Your Ref: OWPC14314
Our Ref: A/103/17/HH 17-05-2017
Please ask for:
Mrs A Gardner

Side extension and replacement of 3 existing windows. This application affects the character and appearance of the Angmering Conservation Area.

6 Longback Cottages Arundel Road Angmering

Thank you for your internet representation made on 21st June 2017 which has been recorded as '**an objection**' with the comments as follows:

Proposed Roof Plan 1:100 @ A3

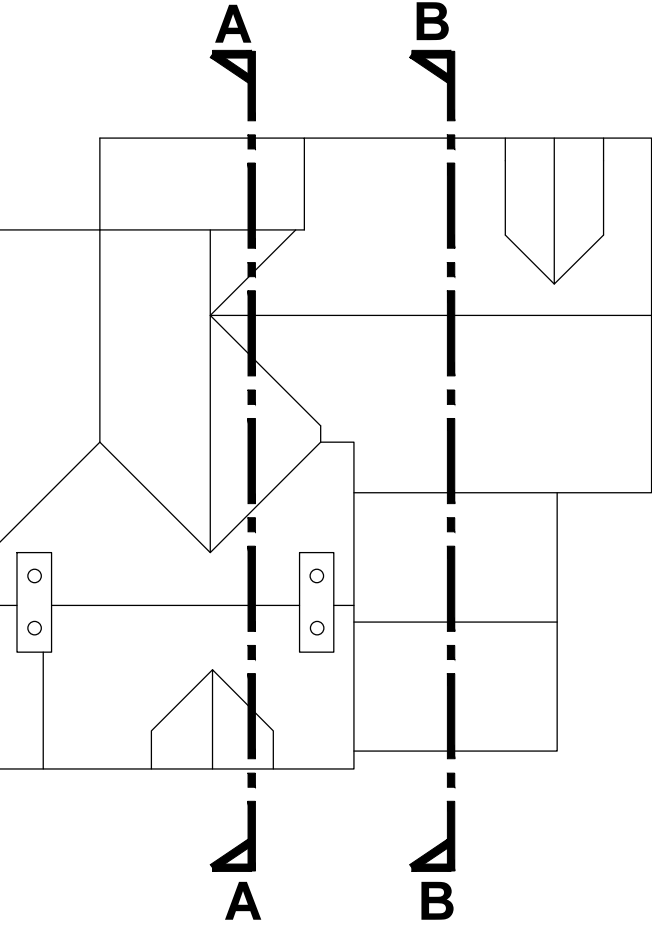
My concern is about the roof reconfiguration possibly putting undue strain on the roofes of the rest of the cottages
